Appeal Decision

Appeal Ref: APP/R5510/W/21/3278249

29 Parkfield Road, Ickenham UB10 8LN

- The appeal is made under section 78 of the Town and Country Planning Act 1990 against a refusal to grant planning permission.
 - The appeal is made by Mr & Mrs S Miah against the decision of the Council of the London Borough of Hillingdon.
 - The application Ref 14459/APP/2021/1343, dated 28 March 2021, was refused by notice dated 27 May 2021.
 - The development proposed is a replacement dwelling and associated parking/landscaping.
-

SITE PLAN
1:500

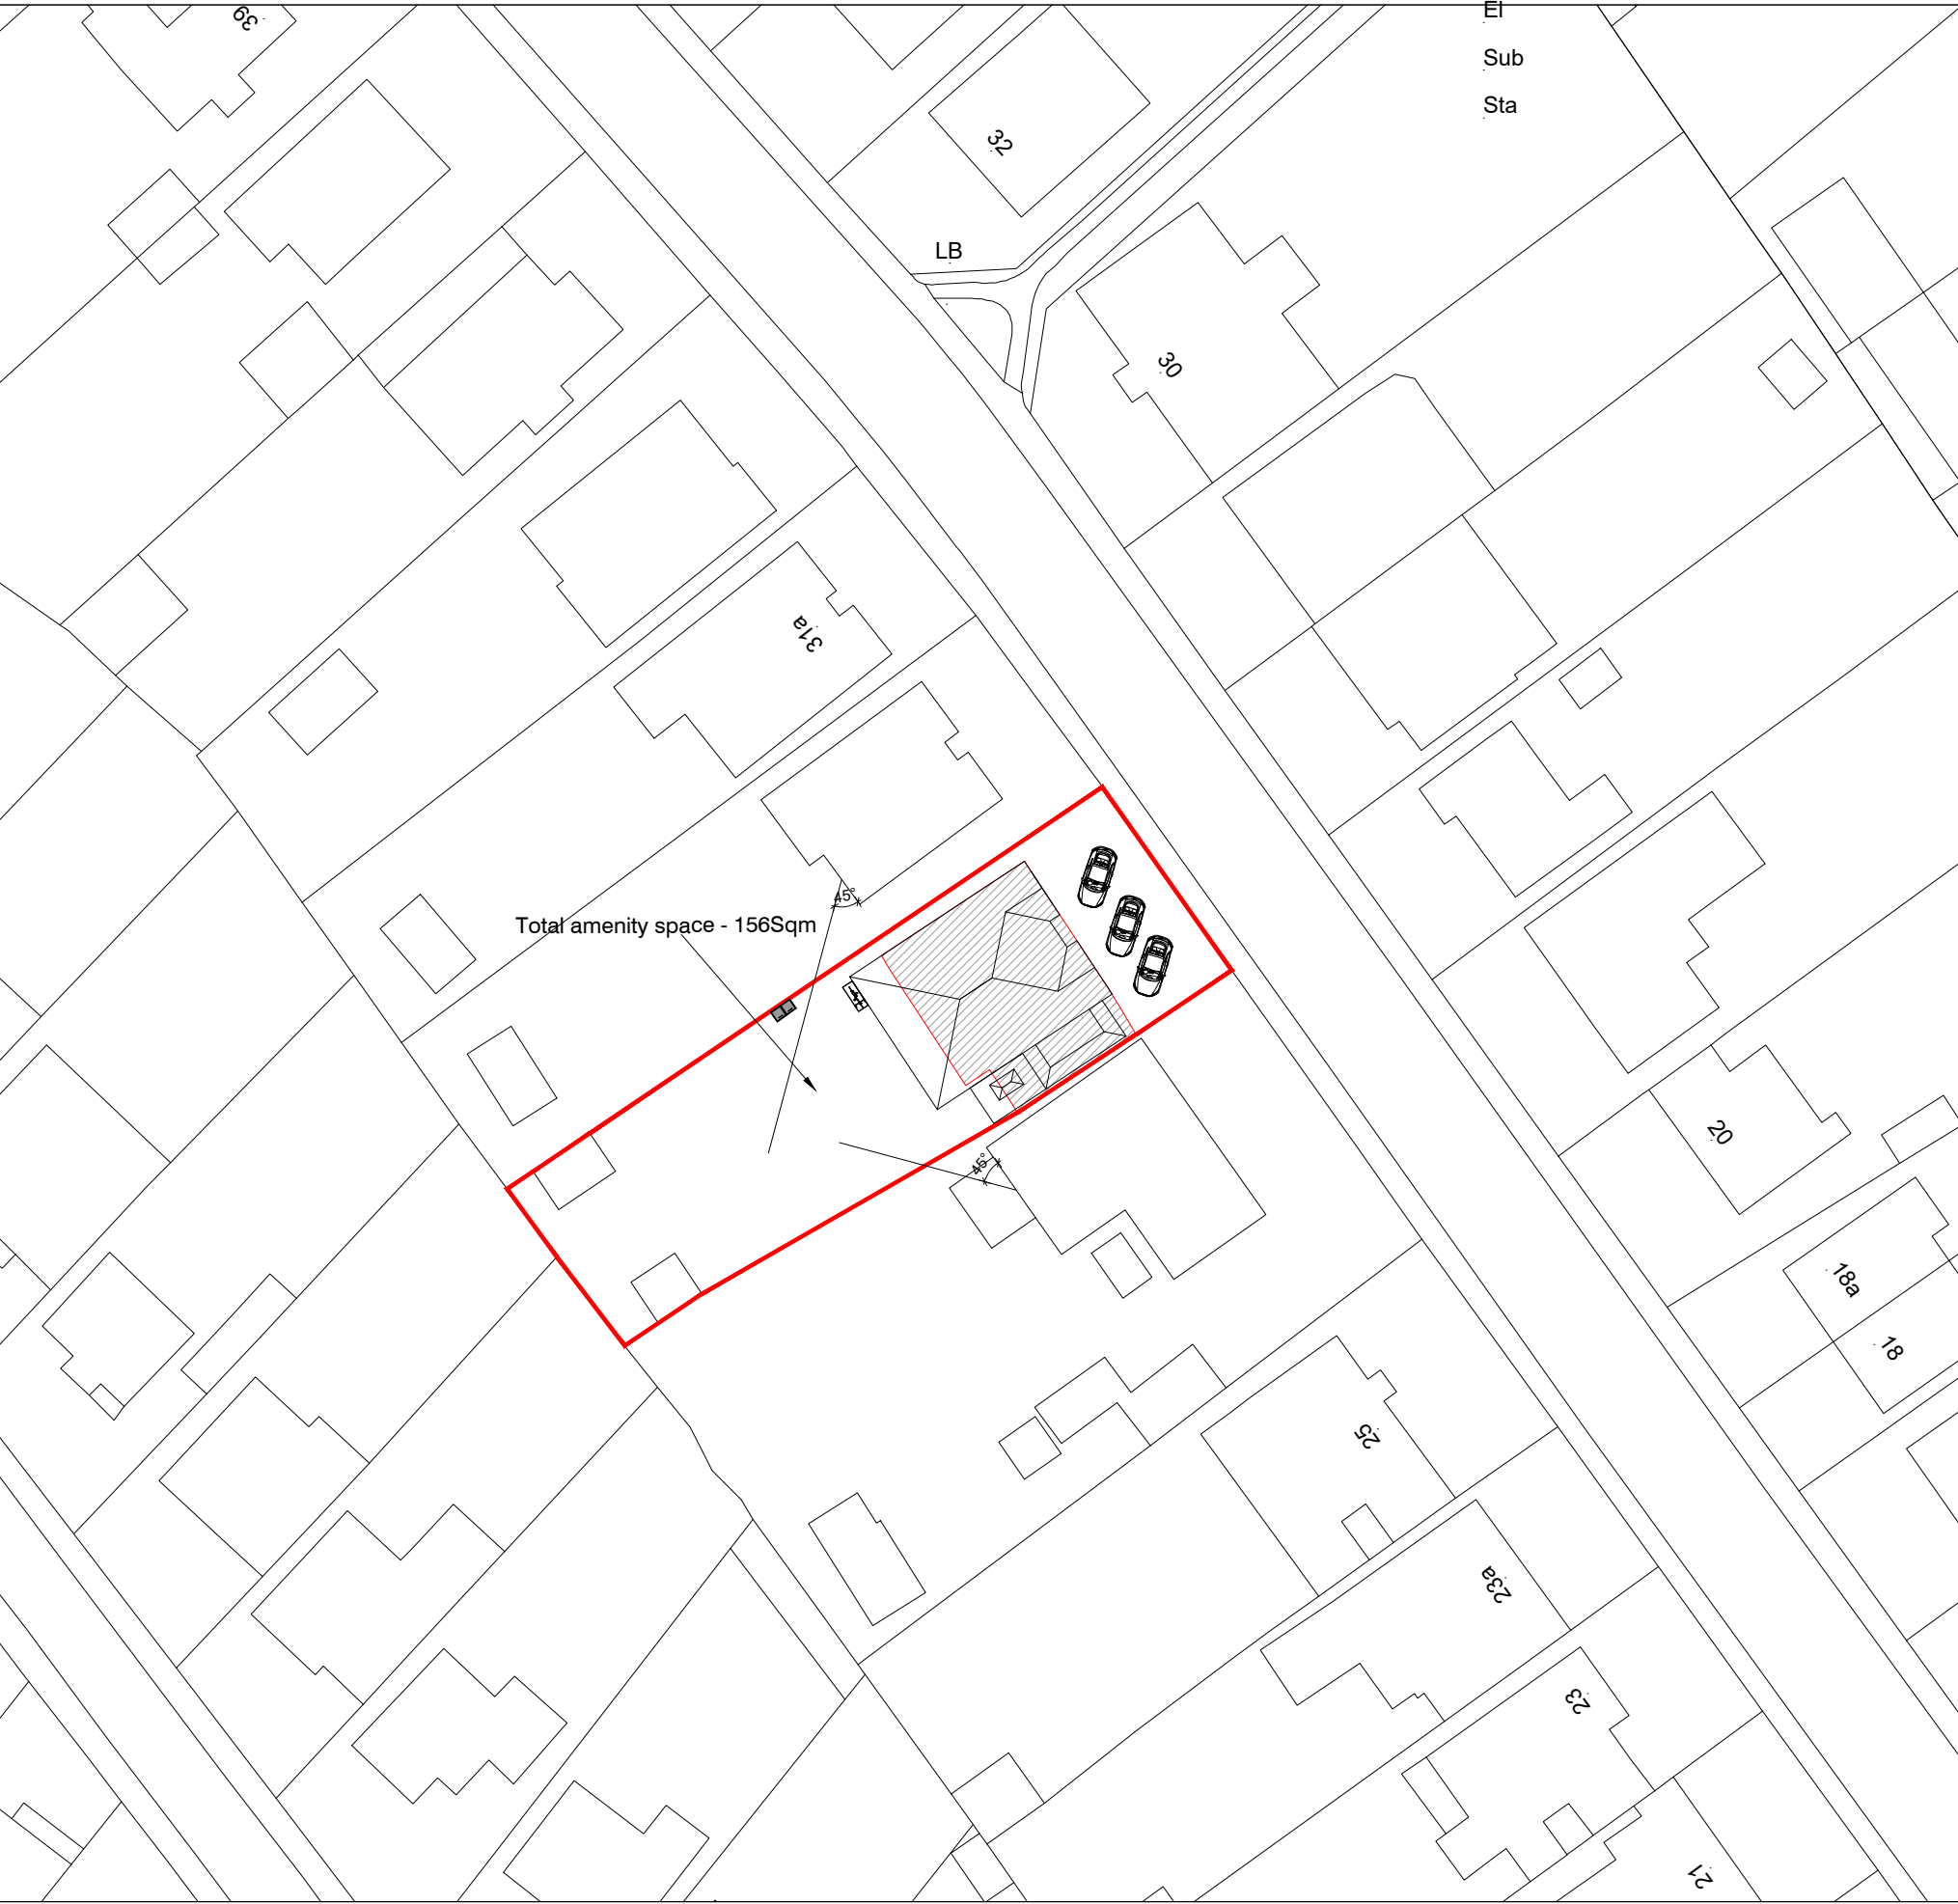
21. The existing property frontage is laid out in a very similar manner to that proposed by the appeal scheme which is, in turn, in keeping with the prevailing pattern of property frontages along Parkfield Road. Whilst I have noted the submitted landscaping plan, I share the Council's concern regarding a relative lack of detail regarding the hard and soft landscaping specifications and the contradiction between the landscape plan and the site plan.

- 4) Notwithstanding the details shown on Drwg No: PA-01 Rev A (Landscape Plan), prior to above-ground works, a landscape scheme shall be submitted to and approved in writing by the Local Planning Authority. The scheme shall include:

PROPOSED FRONT ELEVATION
1:100

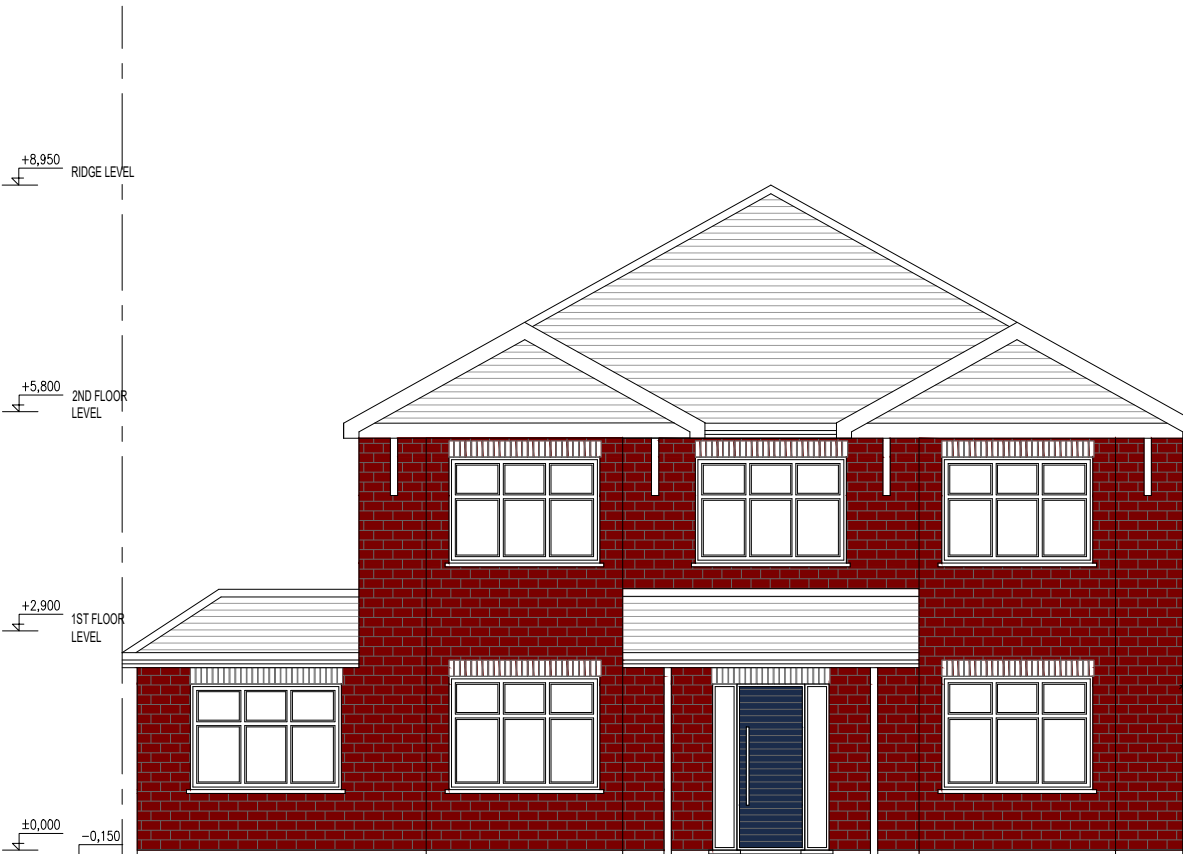
8. The proposed replacement dwelling would be an altogether larger proposition than the existing bungalow and the neighbouring example at No. 27. Moreover, unlike the neighbouring properties to the north, the appeal proposal's full two-storey elevations would mark it out as of a different scale to Nos. 31, 31A and 33.

9. However, it would otherwise reflect other consistent characteristics found along Parkfield Road. It would respect and maintain the building line established by properties along the western side of the road and also maintain the gaps between frontages on either side of the road. The dwelling, despite its substantial overall height, would feature sloping roofs to both side-facing roof planes giving it a hipped-roof appearance, whilst the projecting two-storey bays would also incorporate hipped roofs over.

10. Whilst the transition from the vertical emphasis of the proposed two storey façade to the extensive sloping roof of No. 31 would be somewhat abrupt, it would not be harmfully so in the context of the projecting bays at the front of those neighbouring properties where such juxtaposition is not uncommon. Nor would the transition in scale from No. 27 to No. 29 be unduly harsh, despite their very different scale due to the flat-roofed single storey element at the side of the proposed dwelling. In the context of the street, such single storey flat roofed buildings, or parts of buildings, are not uncommon and this element of the proposed scheme would not appear any more or less so than others.

13. The proposed dwelling is not a beautiful or innovative dwelling, but nor does it purport to be. The front elevation would be well articulated and provide interest to the streetscene whilst incorporating features and details found variously along the road. It would not, as the Council assert, appear squat or bland, whilst final details of construction and fenestration materials could be satisfactorily dealt with by way of an appropriately worded planning condition.

22. Given the proximity and heights of upper floor windows on the side elevations of the replacement dwelling to neighbouring properties it is entirely reasonable and necessary to ensure that they are fitted with obscured glazing in the interests of living conditions and privacy. I have imposed the suggested condition with the addition confirmation that it should apply to first floor windows. I have taken the same approach with suggested condition 6, amending it to ensure that it refers to the correct neighbouring properties.

3. Schedule for ImplementationThereafter the development shall be carried out and maintained in full accordance with the approved details.
- 5) The first floor windows facing Nos. 27 and 31 Parkfield Road shall be glazed with permanently obscured glass to at least scale 4 on the Pilkington scale and be non-opening below a height of 1.8 metres taken from internal finished floor level for so long as the development remains in existence.

- 6) Notwithstanding the provisions of the Town and Country Planning (General Permitted Development)(England)Order 2015 (or any order revoking and re-enacting that Order with or without modification), no additional windows, doors or other openings shall be constructed in the walls or roof slopes of the development hereby approved facing Nos. 27 and 31 Parkfield Road.
